Your ref:
Our ref: 22/00281/F
Please ask for: Mrs Lesley Raby
Direct dial: 01553 616818
E-mail: borough.planning@west-norfolk.gov.uk

8 March 2022

Details: **Proposed conversion of outbuilding to form a single dwelling at The Old Bell 2 Whittington Hill Whittington King's Lynn Norfolk**

1194.01

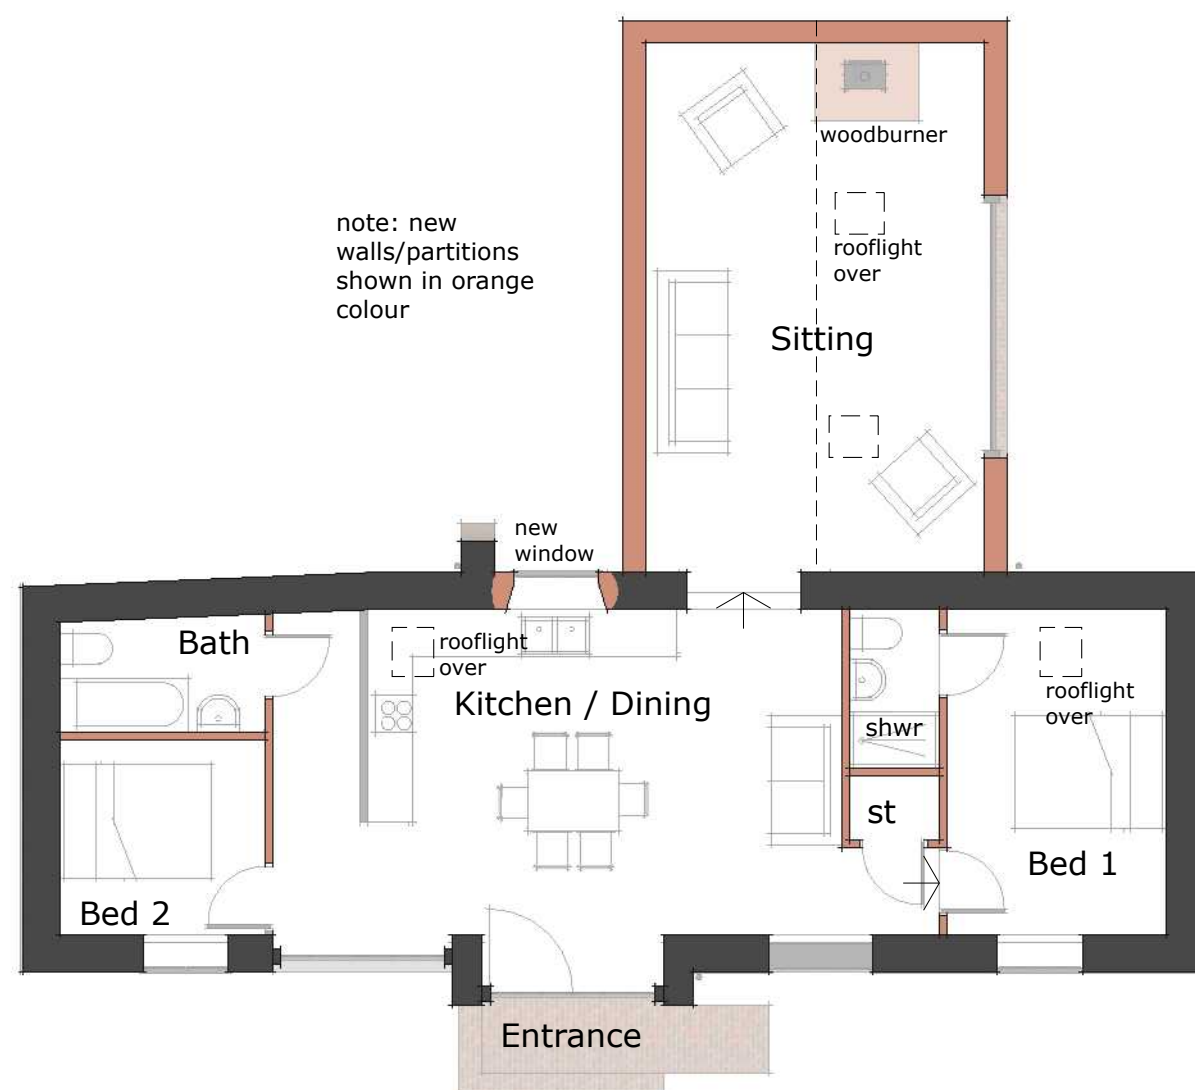
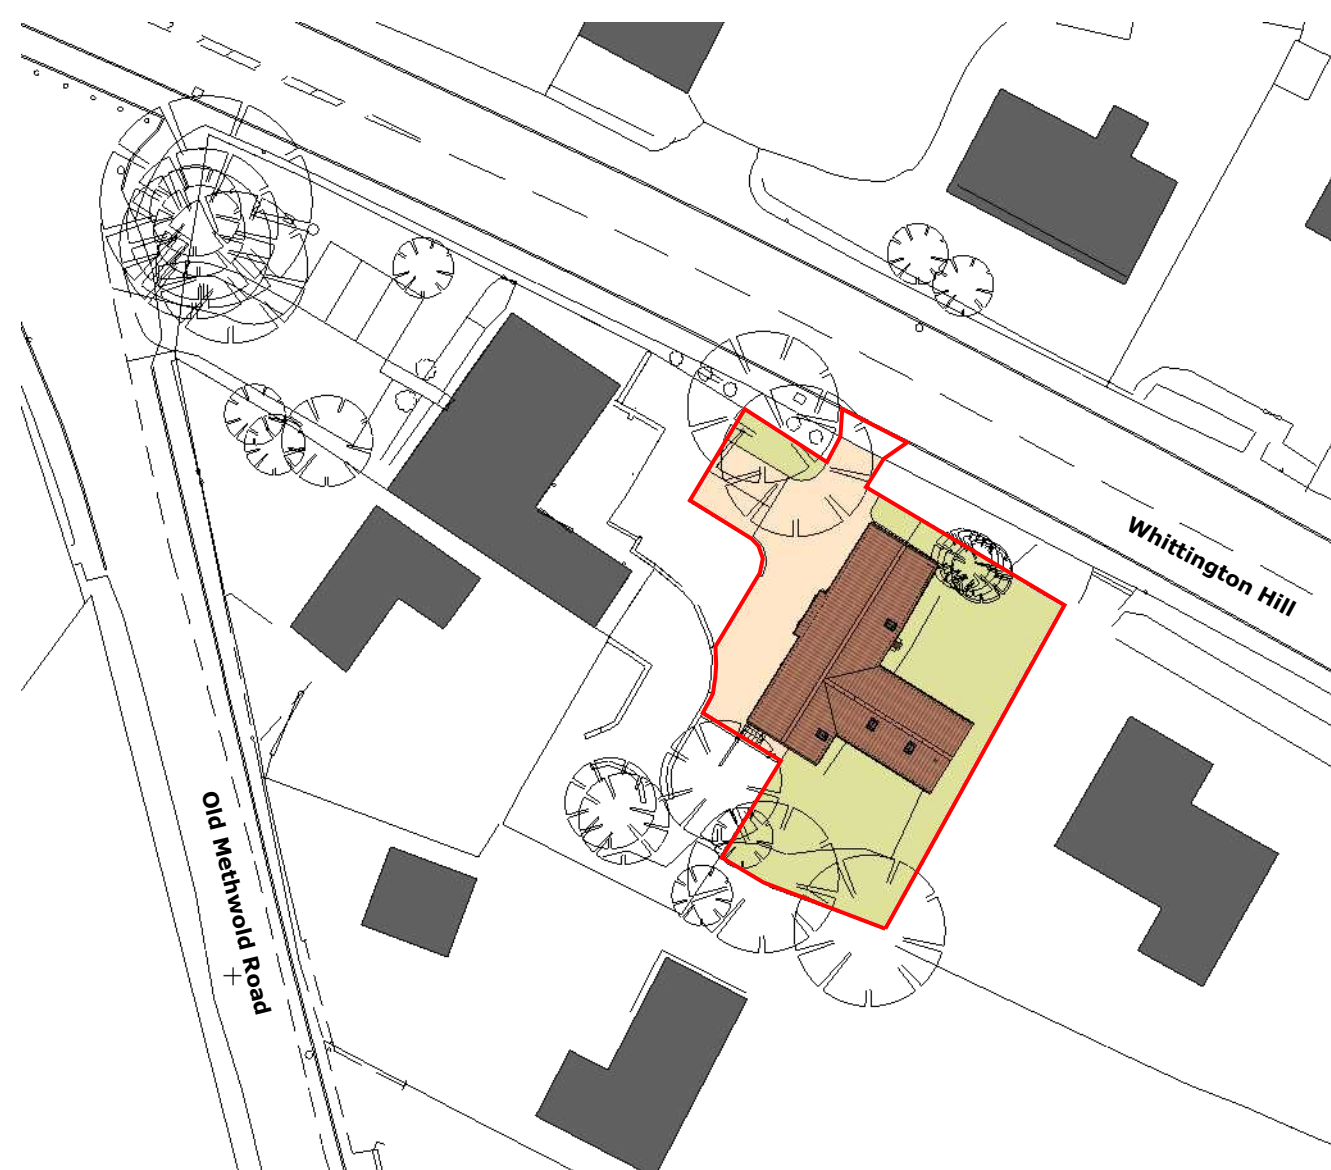
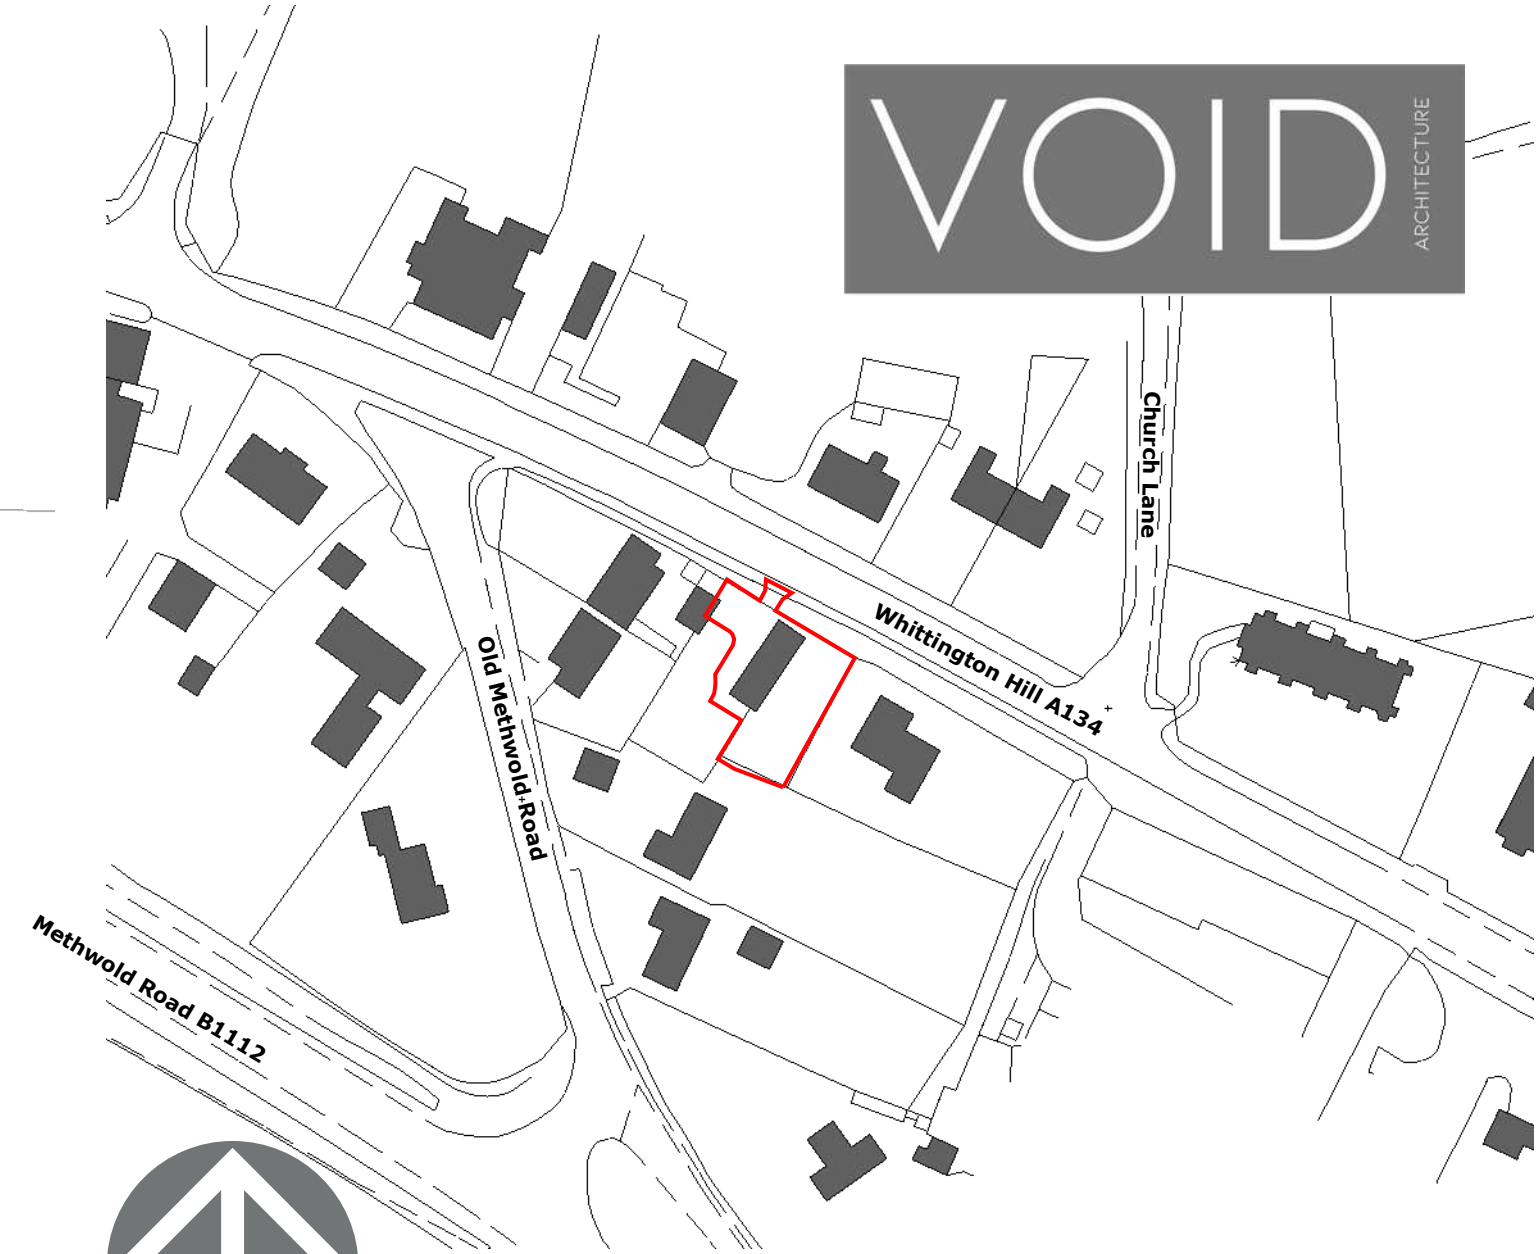
4. Provide the existing floor plan and elevations of the building.
5. Confirm the finished floor levels will be the same as existing and the site levels will remain unchanged.
